August 8, 2024

Re: Comment Response Letter to the Site Development Plan, for  
PCD File # PPR2419  
Church of Jesus Christ of Latter-day Saints  
Owner contact: Scott Hollister, (719) 481-2609, (HollisterSJ@ChurchofJesusChrist.org)  
Address: 950 CO-105, Monument, CO 80132  
Tax Schedule number: 7113210037

We have compiled comments from the El Paso County Planning and Community Development, and referral agencies. We have prepared this Comment Response Letter as part of the resubmittal to El Paso County specific to the comments of the Site Development Plan. Drexel Barrell has prepared a separate letter for the engineering comments.

SITE DEVELOPMENT PLAN FOR THE CHURCH OF JESUS CHRIST OF LATTER-DAY SAINTS

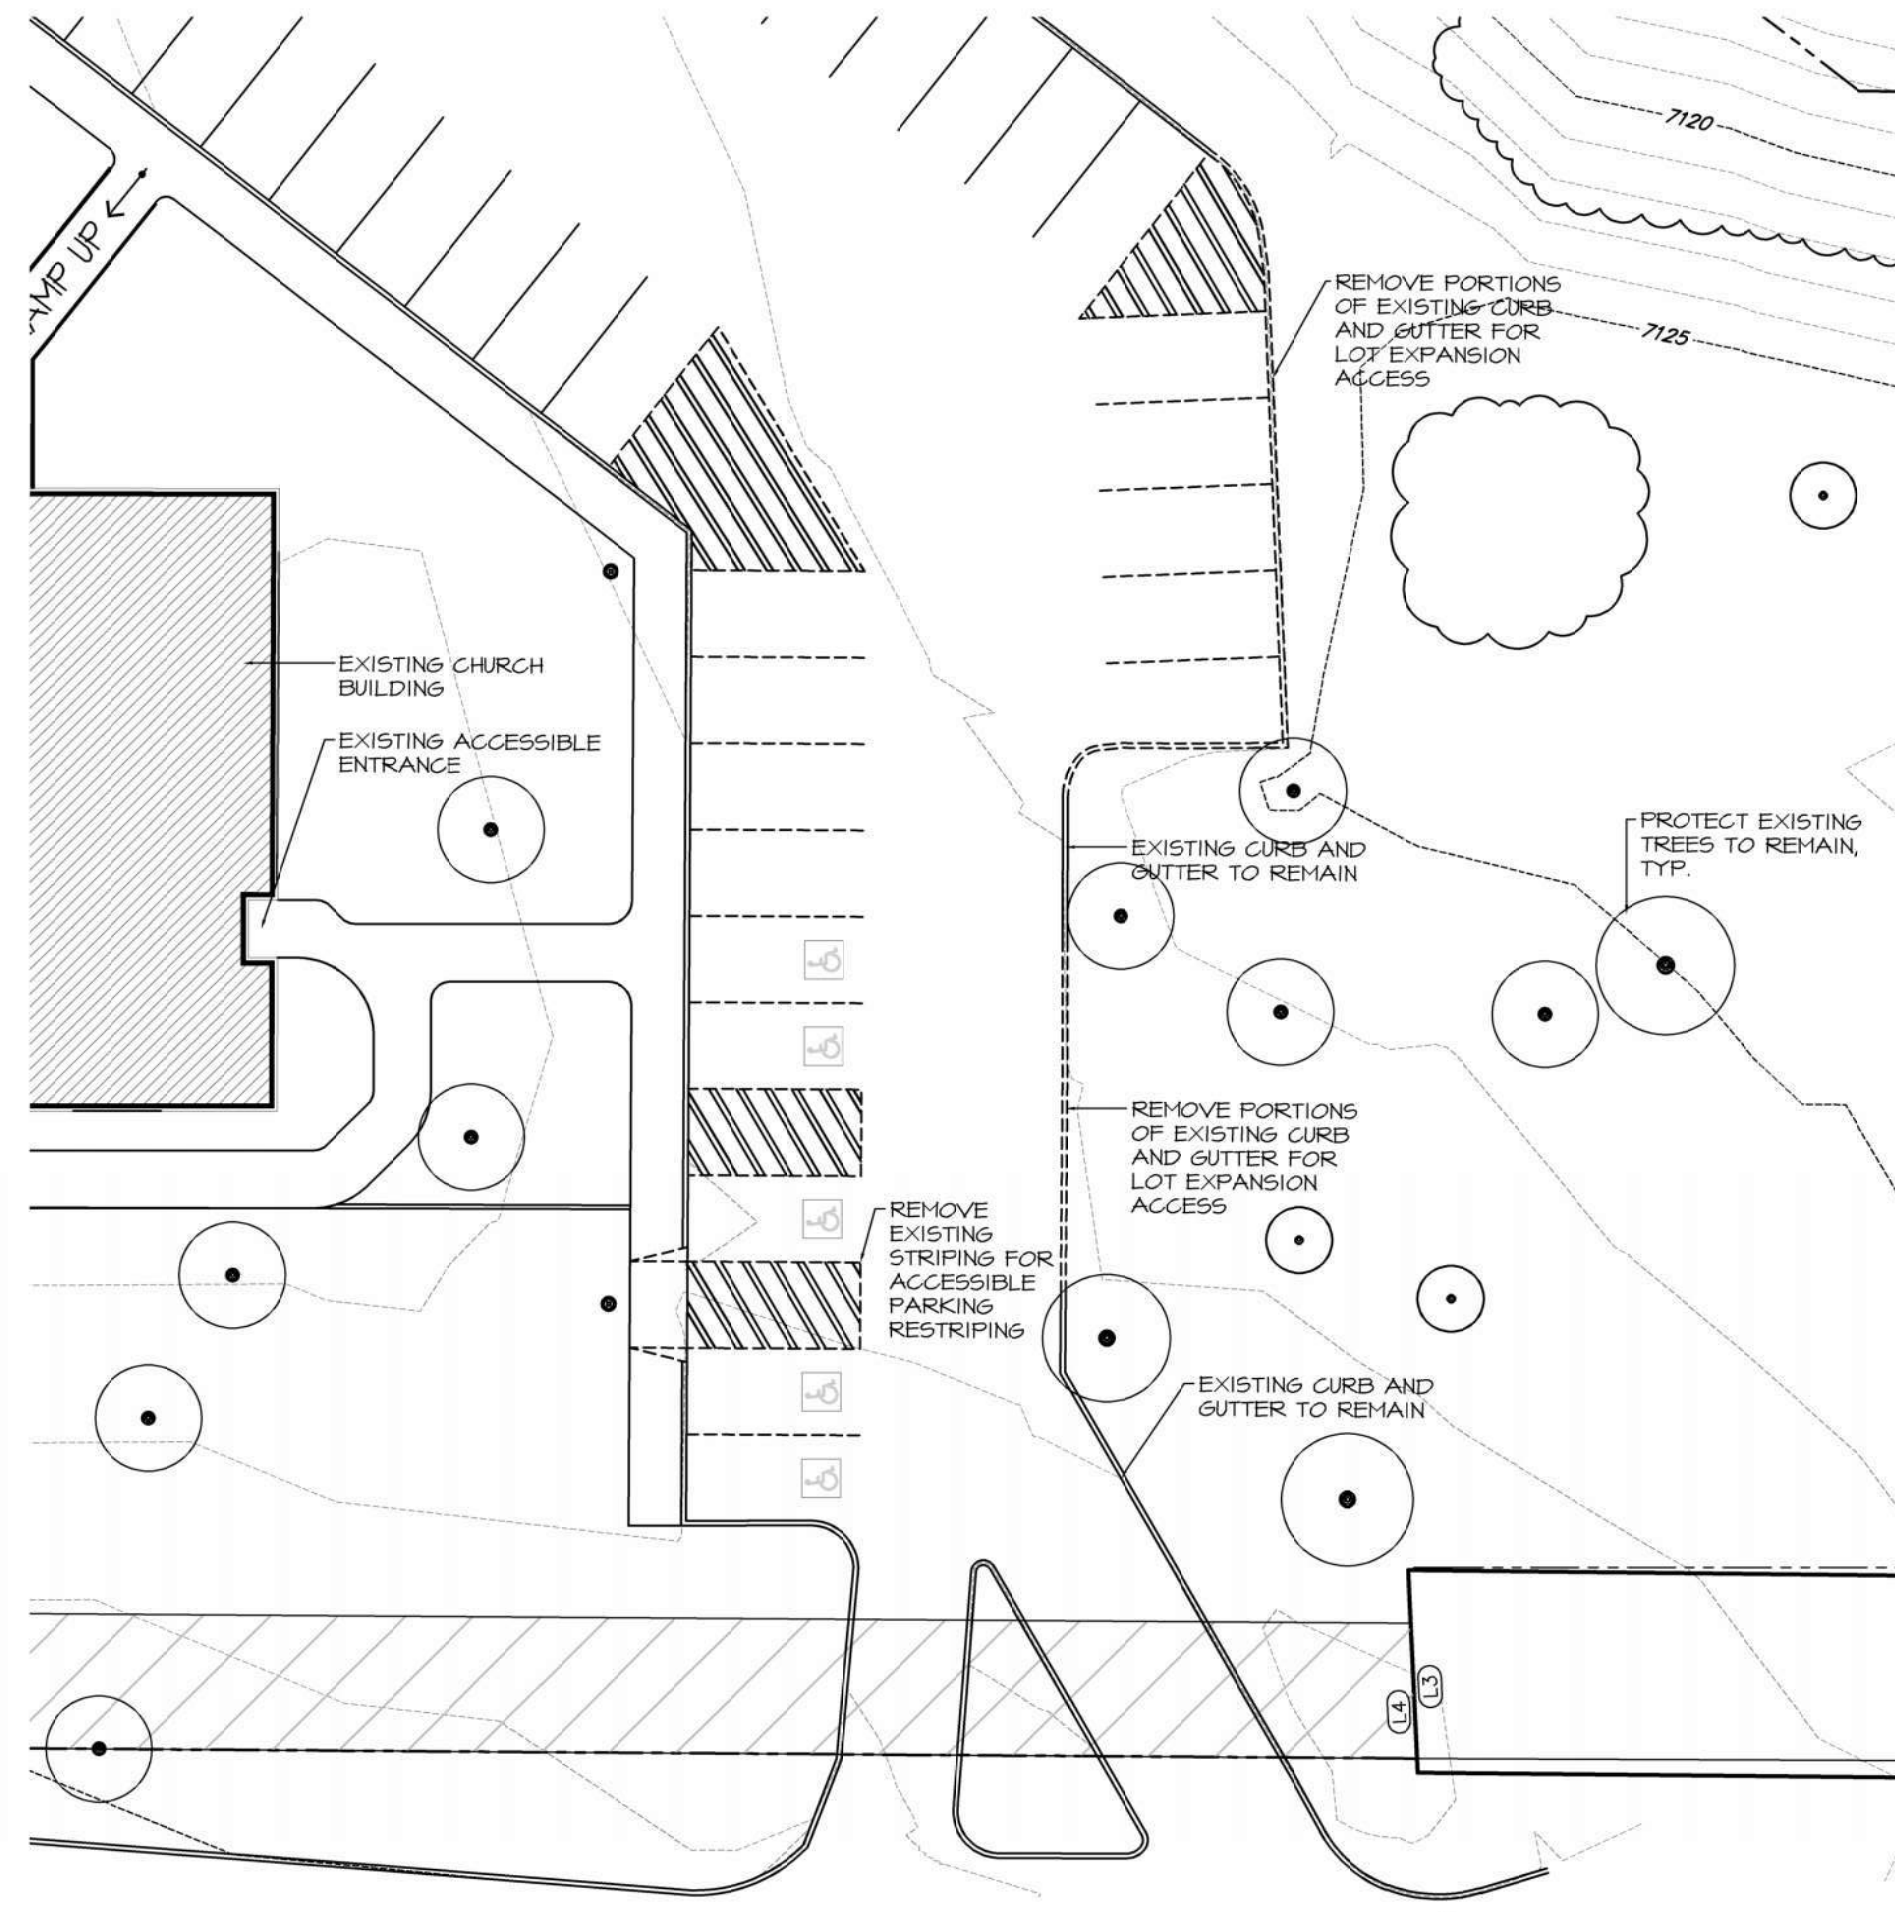
#### Sheet C-1

Developer shall comply with federal and state laws, regulations, ordinances, review and permit requirements, and other agency requirements, if any, of applicable agencies including, but not limited to, the Colorado Division of Wildlife, Colorado Department of Transportation, U.S. Army Corps of Engineers and the U.S. Fish and Wildlife Service regarding the Endangered Species Act, particularly as it relates to the listed species (e.g., Preble's Meadow Jumping Mouse). Monument Fire Department has commented: This project is not adding new buildings and will not affect the needed fire flow for the existing building. The fire district will not require additional fire hydrants to be added for this project.

No driveway shall be established unless an access permit has been granted by El Paso County.

##### PCD File #PPR2419

Zone: RS-2000 is not being modified just the R4 PUD portion which established parking on this site

Coverage Data: Clarify that no addition is proposed these numbers are existing; only parking is being expanded.

[Noted, annotation added to sheet.](#)

[Noted, annotation added to sheet.](#)

[File # has been added.](#)

[Change has been implemented to just the R4](#)

Parking Lot annotation has been added

Building coverage is annotated as Existing

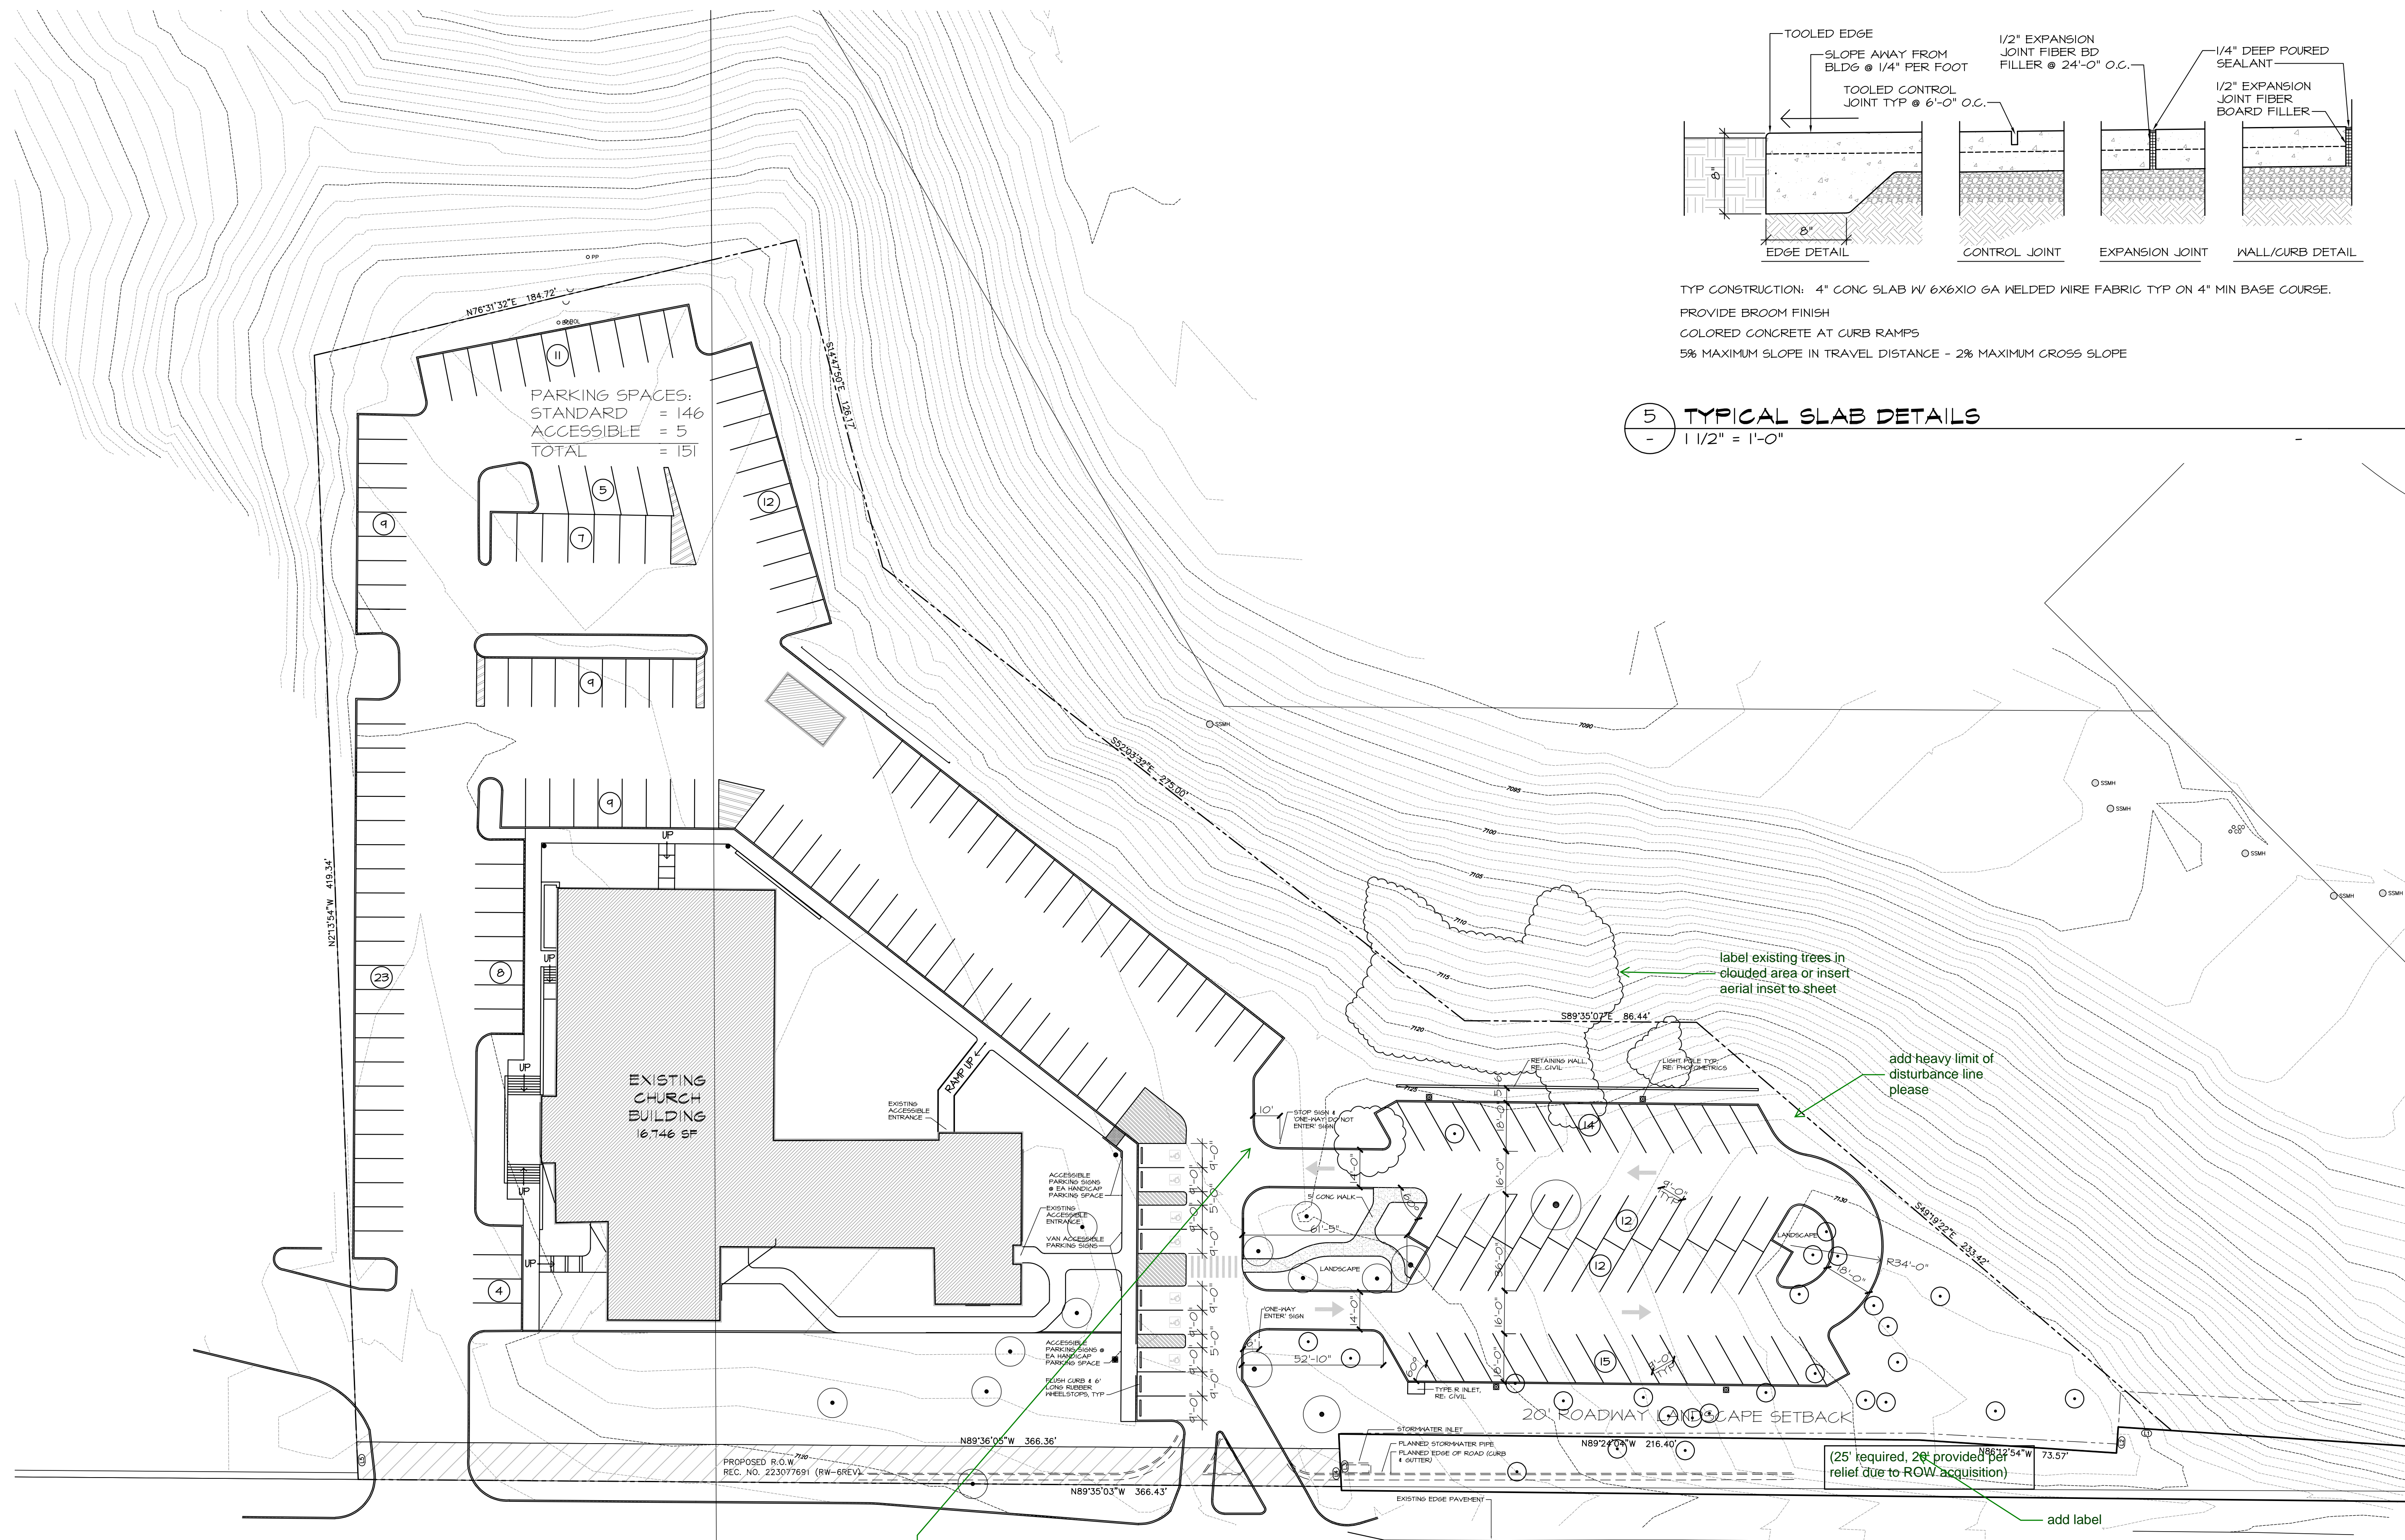
25' required, 20' provided per relief due to ROW acquisition:

Add heavy limit of disturbance line please:

label existing trees in clouded area or insert aerial inset to sheet:

clearly label line for new development area from existing development area and or grey existing development not changing back

The linework for the rest of the parking lot is the same as the proposed. Please make it more clear what is existing and what is proposed.

Clearly label line for new development area from existing development area and or grey existing development not changing back

Call out hydrant

Call out gas meter

Add stop sign

Call out Do Not Enter sign

Call out no left turn sign

Labelling has been added along the south boundary

A thick gray dashed line has been added to define the disturbance area

The forested areas have been annotated EXISTING TREES, and an aerial image of the same scale has been added to the sheet, aligning with the drawn plan.

The edge of existing is now shown with a dashed line, and with annotation. New drive in and drive out are annotated

The existing has been indicated with gray line tone. Additional labelling is provided.

Existing development has gray graphics and additional labelling is provided

Annotation added

Annotation added

The existing stop sign is annotated

DO NOT ENTER sign is annotated

NO LEFT TURN sign is annotated
